Your ref: 3/2022/0023
Our ref: D3/2022/0023
Date: 16 February 2022

Planning Application No: 3/2022/0023

Proposal: Extension to front and side including replacement dormer to rear and dormer in side extension. Insulated rendered cladding to existing walls.

Location: 53 Lower Lane, Longridge PR3 3SQ

Proposed Site / Roof Plan

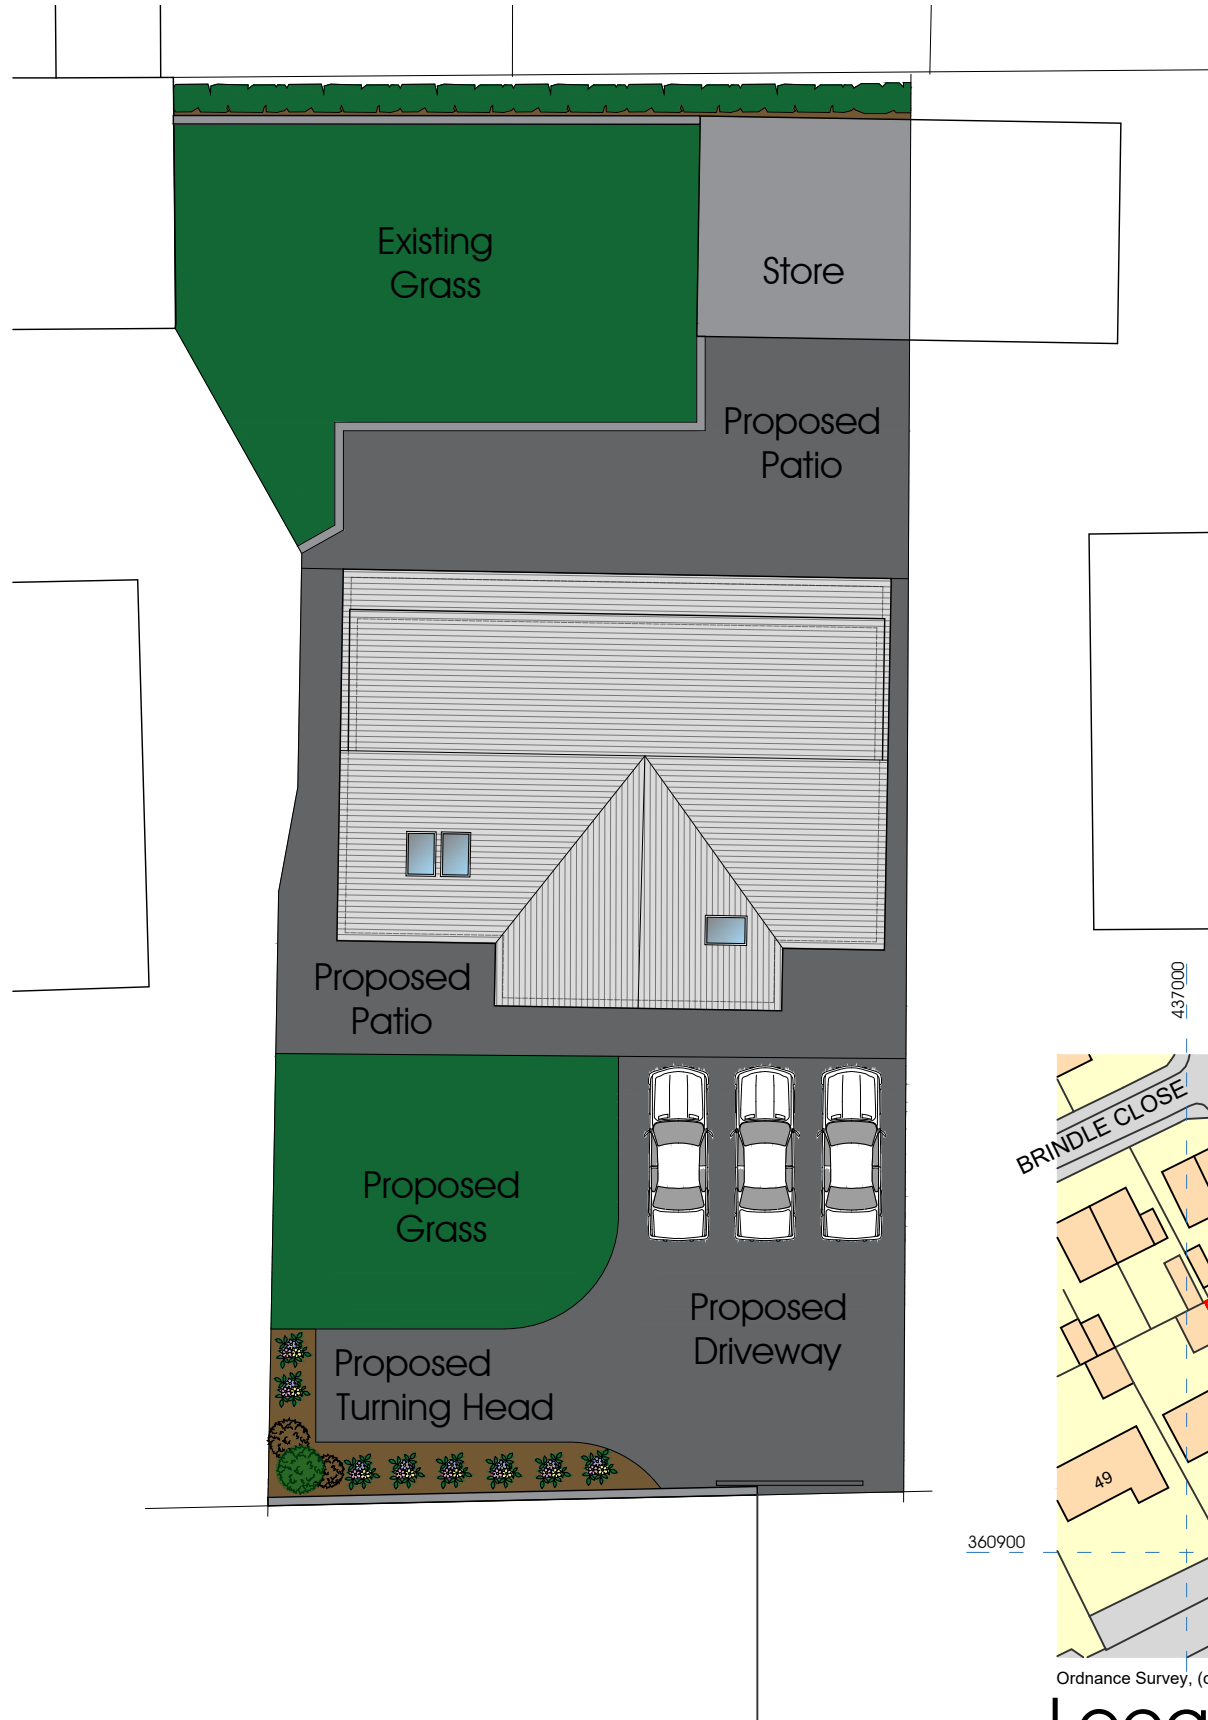
Three off-road parking spaces are proposed at the front of the dwelling. This area of hardstanding should be a minimum of 8.2m wide. This would allow both pedestrian and vehicular access (3.2m) and where a parking space is adjacent to a wall or fence this should be a minimum of 2.6m wide to provide additional room to open a vehicle door.

A new internal turning area has also been introduced to the left of the vehicular access. This should be kept free from obstructions to allow vehicles to enter and leave the site in forward gear.

The proposed development should not be brought into use unless and until the parking and manoeuvring areas shown on the approved plans have been constructed, laid out and surfaced in bound porous materials. The parking area shall thereafter always remain available for the parking of domestic vehicles associated with the dwelling. Reason: In order to ensure satisfactory levels of off-street parking are achieved within the site and to allow vehicles to enter and leave in forward gear.
